From: Kevin Bown [REDACTED]
Sent: 06 April 2023 16:06
To: David Easton <David.Easton@arun.gov.uk>; Planning.Responses
<Planning.Responses@arun.gov.uk>
Cc: [REDACTED] Planning SE [REDACTED] Spatial
Planning [REDACTED] Elizabeth
Cleaver [REDACTED] Diana Ngobi
[REDACTED]
Subject: National Highways Response: BN/11/22/OUT Barnham, Eastergate, Westergate BEW Parcel
SC1 Barnham

National Highways Planning Response (NHPR 22-12)

Location: Barnham, Eastergate, Westergate BEW Parcel SC1 Barnham

Proposal: Outline application with all matters reserved (except for the A29 Realignment) for the demolition of existing structures and mixed use development to provide residential dwellings (Use Class C3), Care Home/Senior Living Accommodation (Use Class E/F2/Sui Generis), a Primary School plus open space, landscaping, drainage and all other associated ancillary works; and realignment of the A29 and early connection to existing A29 including construction of a new road carriageway, junctions and associated infrastructure. This application also lies within the parish of Aldingbourne, affects the setting of listed buildings, affects the character & appearance of the Eastergate Church Lane Conservation A

Figure 6.6: Arun District Transport Study – Stage 3 scheme for the A27/ Fontwell Avenue junction

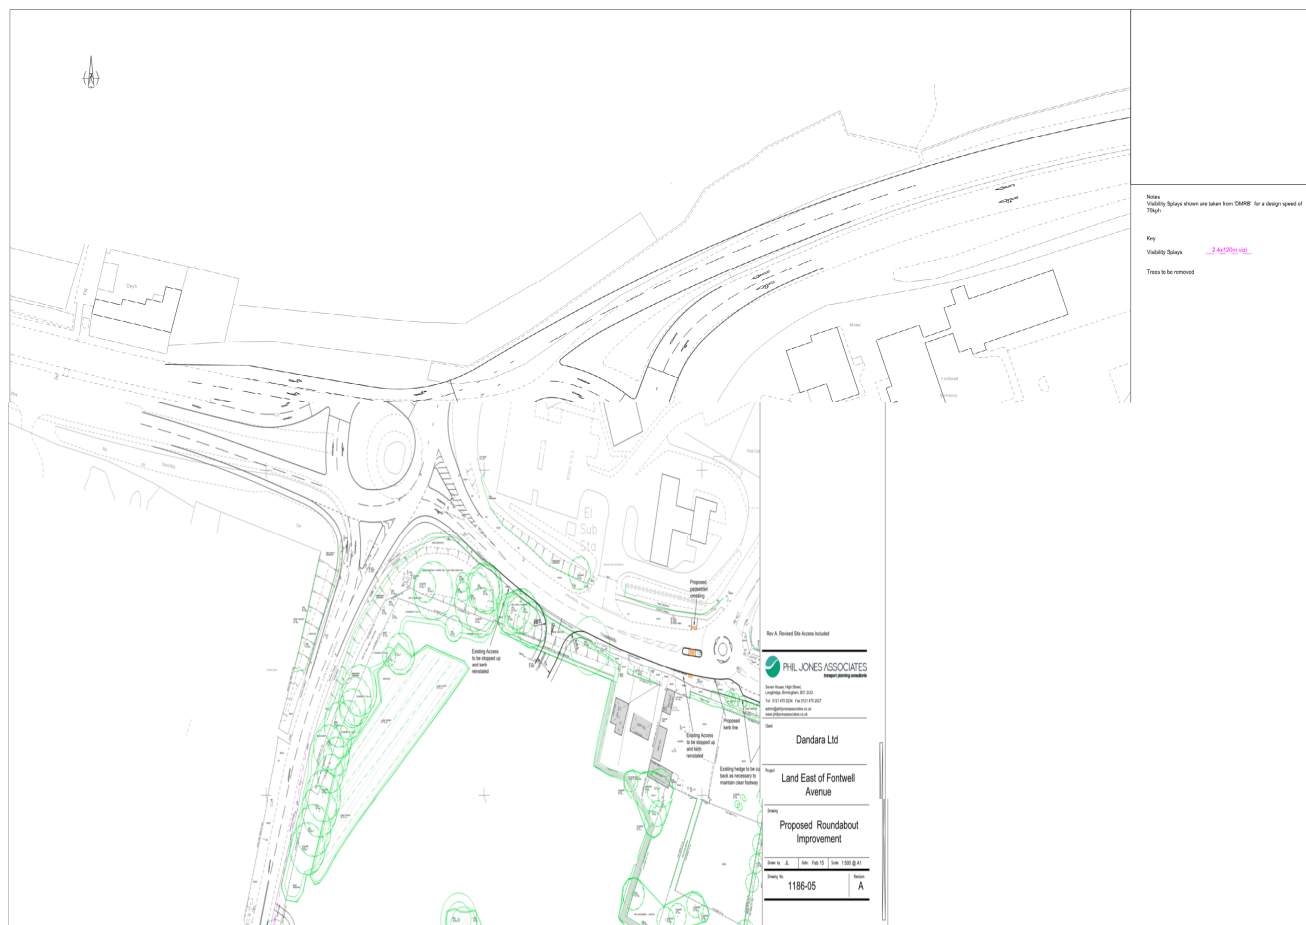
It is stated within the additional information submission of 22 November that the 2031 and 2038 DM and DS modelling is based upon the mitigation scheme proposed in the Arun Transport Study Stage 3 report.

The assessment of the queues within the 22 November 2022 technical note acknowledges the substantial growth in queues on the A27 North and A27 Arundel Road West arms in the AM and PM peaks. It is noted that the summary table includes all queuing vehicles, which are in practice split across two lanes on each arm. Drawings have been provided in the 22 November response showing the physical measured extent of the queues during the busiest scenarios; for the Arundel Road West arm this is stated to be 223 PCUs, however in the model output files the highest recorded length is 79.8 PCUs. For the A27 North arm, the 22 November response

states a highest queue value of 131 PCUs, whereas the model output files state a figure of 458 PCUs.

Further explanation is required in relation to the discrepancies between the analysis within the 22 November technical note and the information within the supplied model output files. The queue length measurement drawings should be revised to correspond to the submitted model output data.

Figure 6.10: A29/ A259 Rowan Way/ Shripney Road Roundabout mitigation scheme

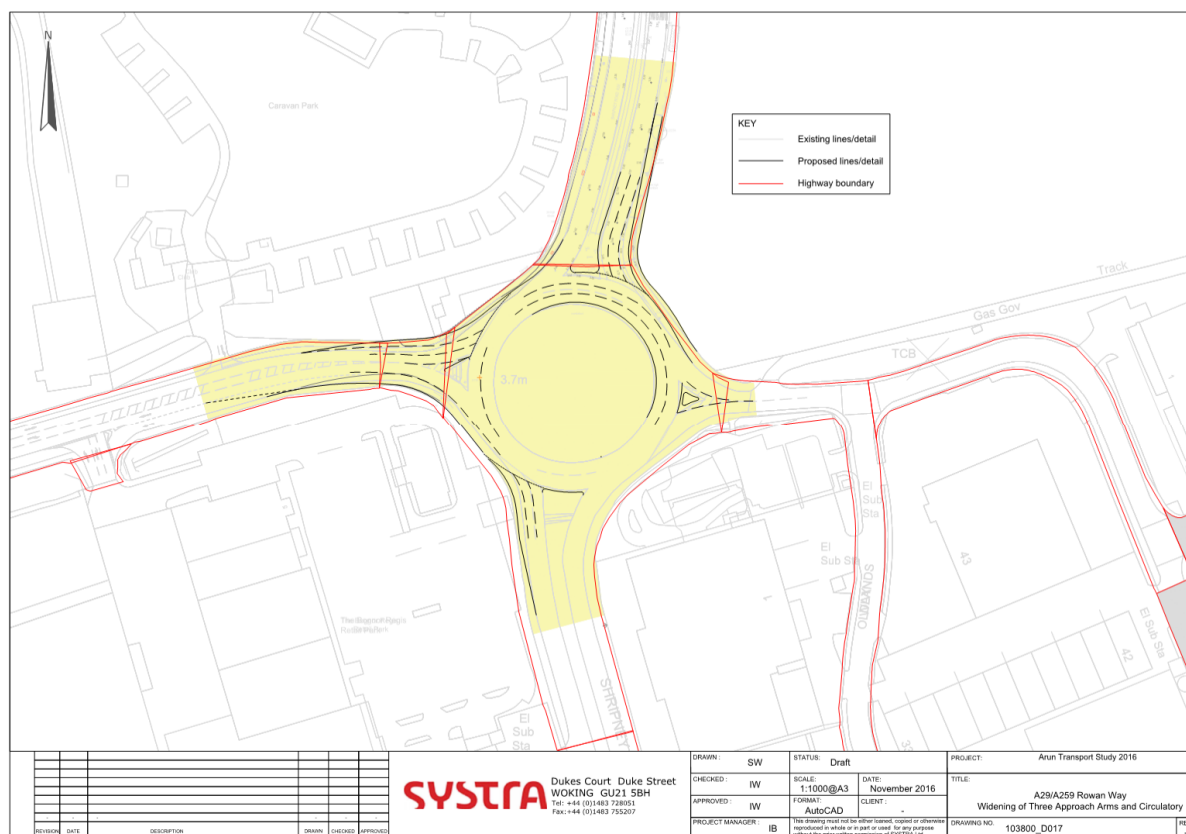
It is also noted that we have identified that the mitigation scheme presented in the Arun study Stage 3 has been superseded by the mitigation proposals associated with the Enterprise Bognor Regis review; as such, a further test will be required which appraises the proposed development impacts against this scheme. We are currently preparing a model for use by the applicant to carry out the required sensitivity test and this will be provided accordingly.

The required sensitivity test of the mitigation measures proposed in the Enterprise Bognor Regis review for the A27 Bognor Road roundabout should be conducted using the model to be provided by us.
